WEST SUSSEX COUNTY COUNCIL CONSULTATION

TO:	Arun District Council FAO:David Easton
FROM:	WSCC - Highways Authority
DATE:	6 April 2022
LOCATION:	Land West of Pagham Road Pagham
SUBJECT:	P/155/21/RES Approval of reserved matters (layout, scale, appearance and landscaping) following outline consent P/140/16/OUT for the 'local centre' parcel which comprises of retail, community and commercial uses, 20 No residential apartments and a 70 bed care home.
DATE OF SITE VISIT:	n/a
RECOMMENDATION:	No Objection
S106 CONTRIBUTION TOTAL:	n/a

SPINE ROAD AND
LOCAL CENTRE ACCESS

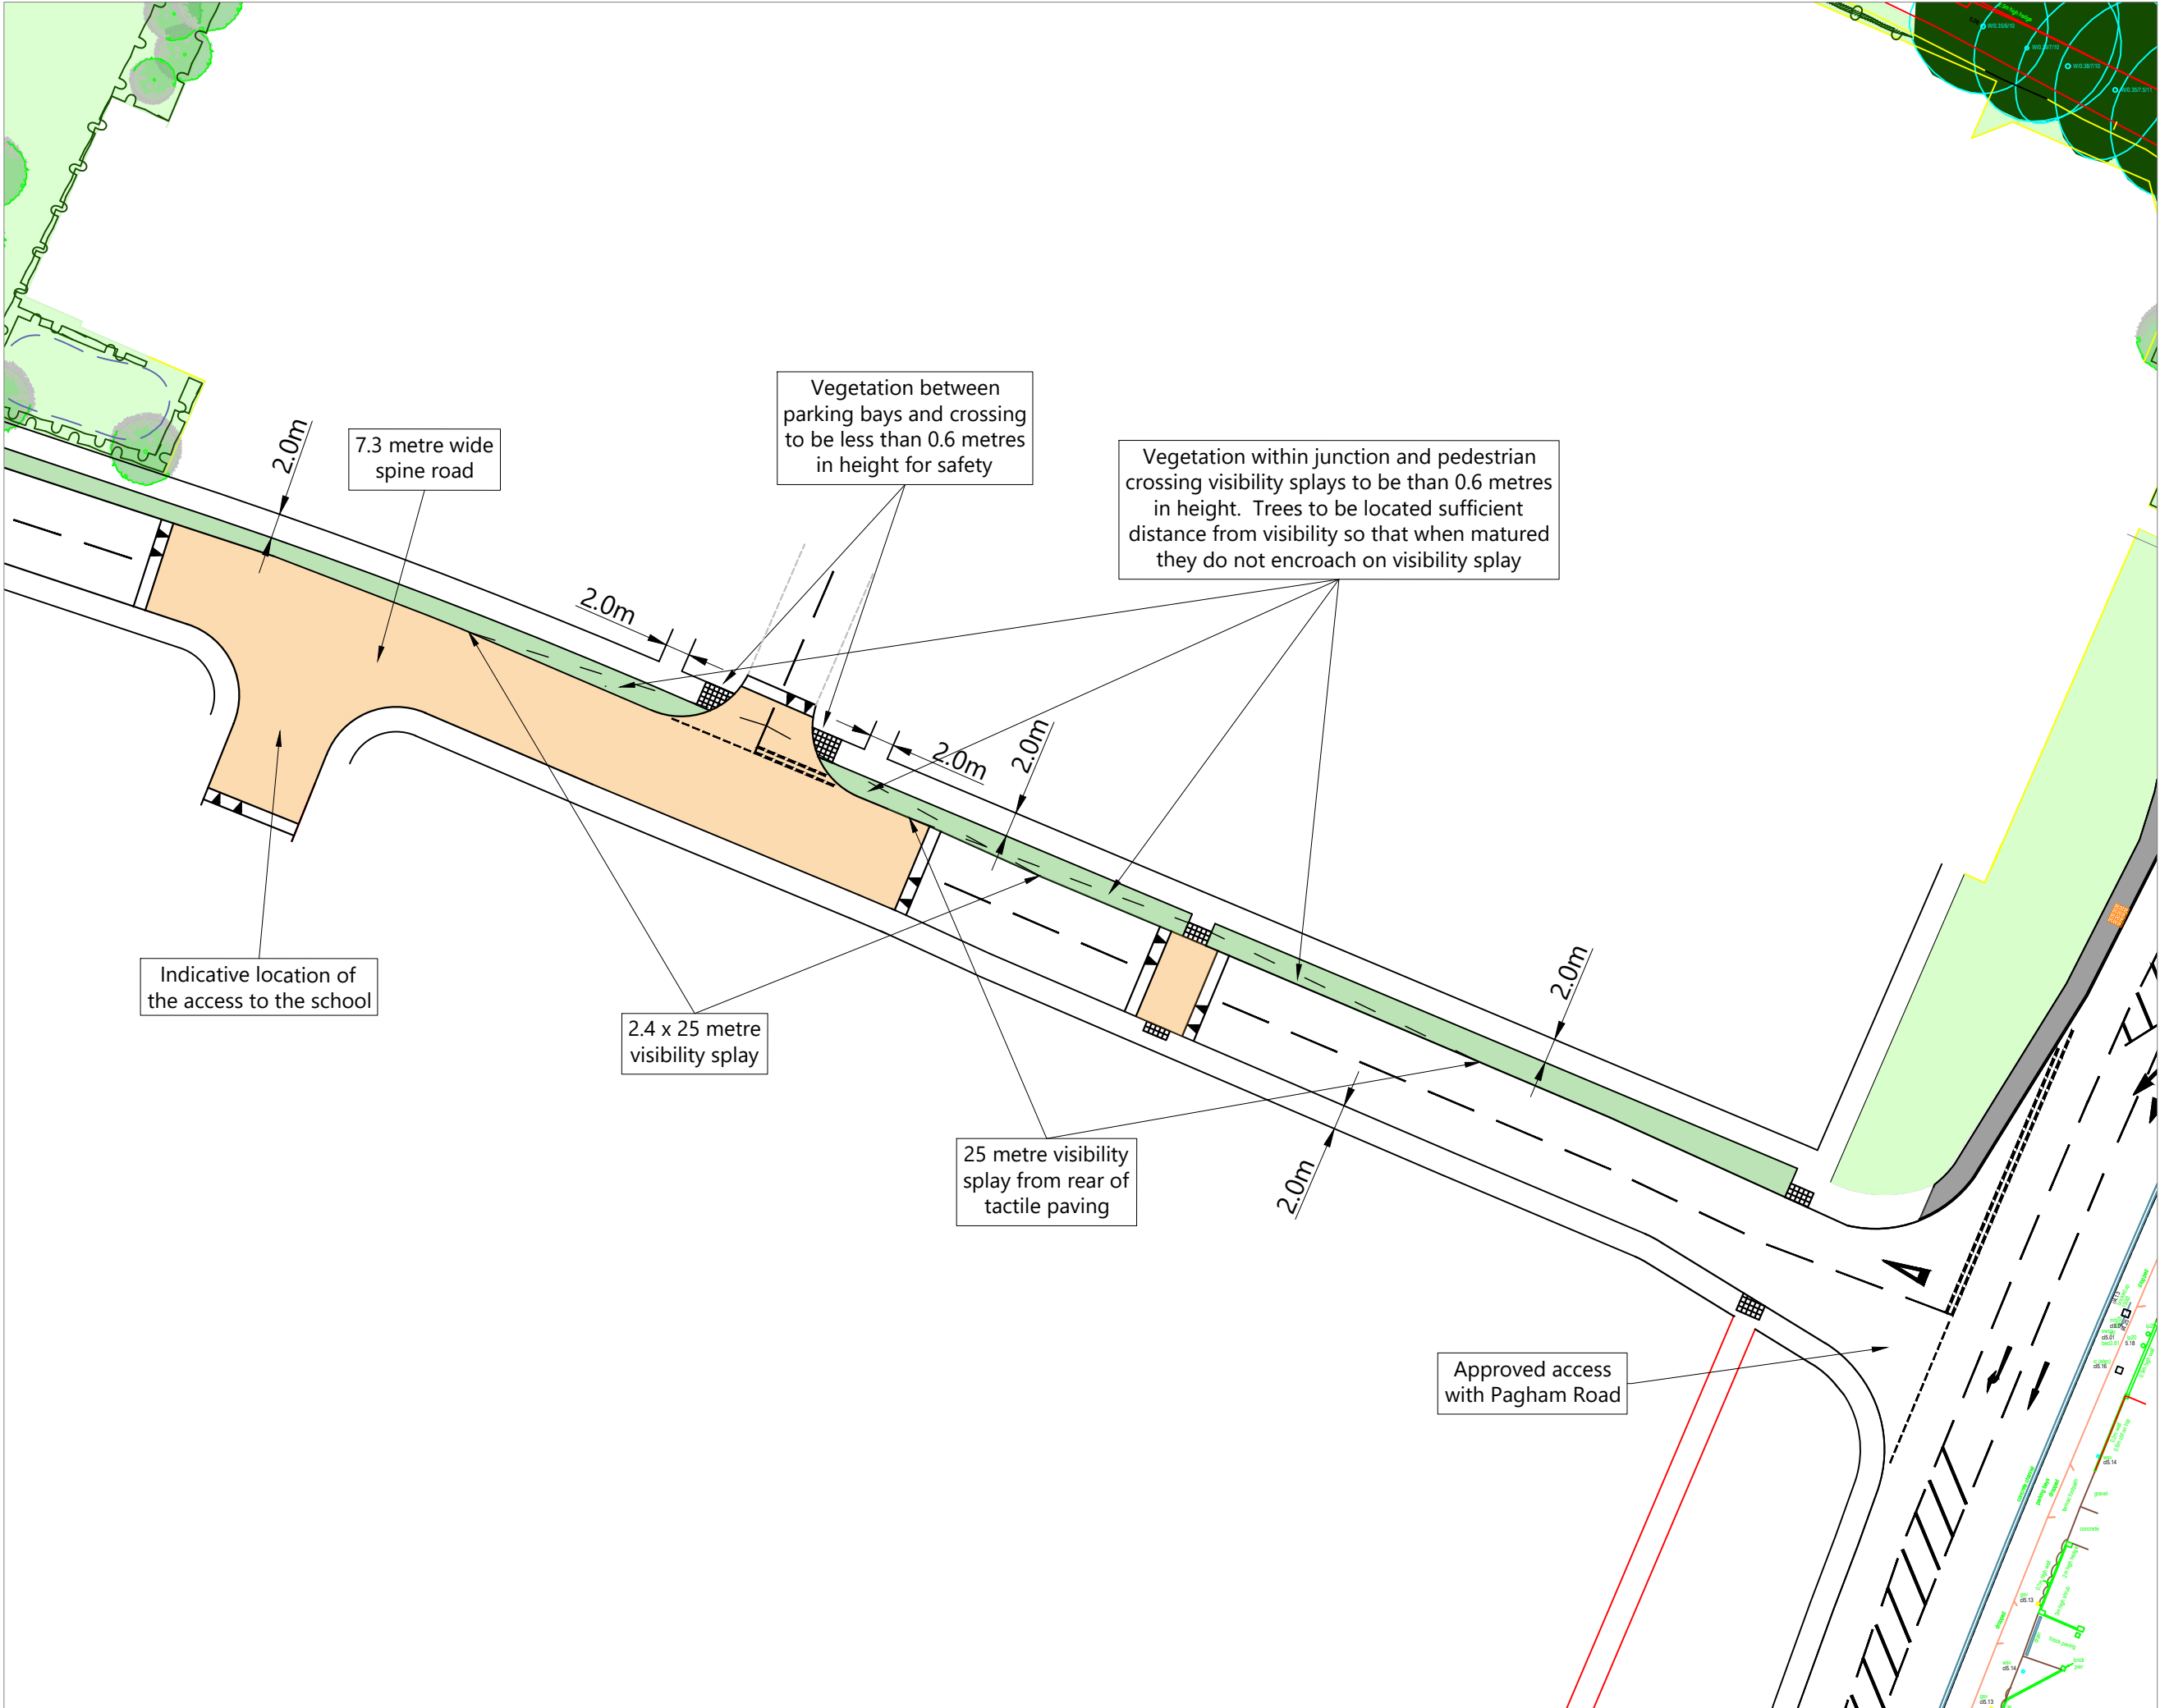
As requested by WSCC and contrary to point 10 of the submitted Technical Note, the access road has now been road safety audited. The audit raises no in principle problems. A number of changes are required by the audit to the extent

of waiting restrictions and raised tables. These changes have been agreed with WSCC Highways.

In addition to those points raised through the road safety audit, further works are proposed to the access road in terms of additional lengths of waiting restrictions and 'school – keep clear' markings. These restrictions are proposed to manage the potential parking demands arising from the school. The applicant should note that a traffic regulation order will be required to make the waiting restrictions enforceable. It's acknowledged that further alterations may take place to the access road through any application for the school itself.

No part of the development shall be first occupied until the access road has been provided in accordance with the details as shown on Spine Road and Local Centre Access, sheets 1, 2, and 3, drawing number 07 revision G, and Indicative Proposed Road Markings, sheets 1 and 2, drawing 08 revision C.
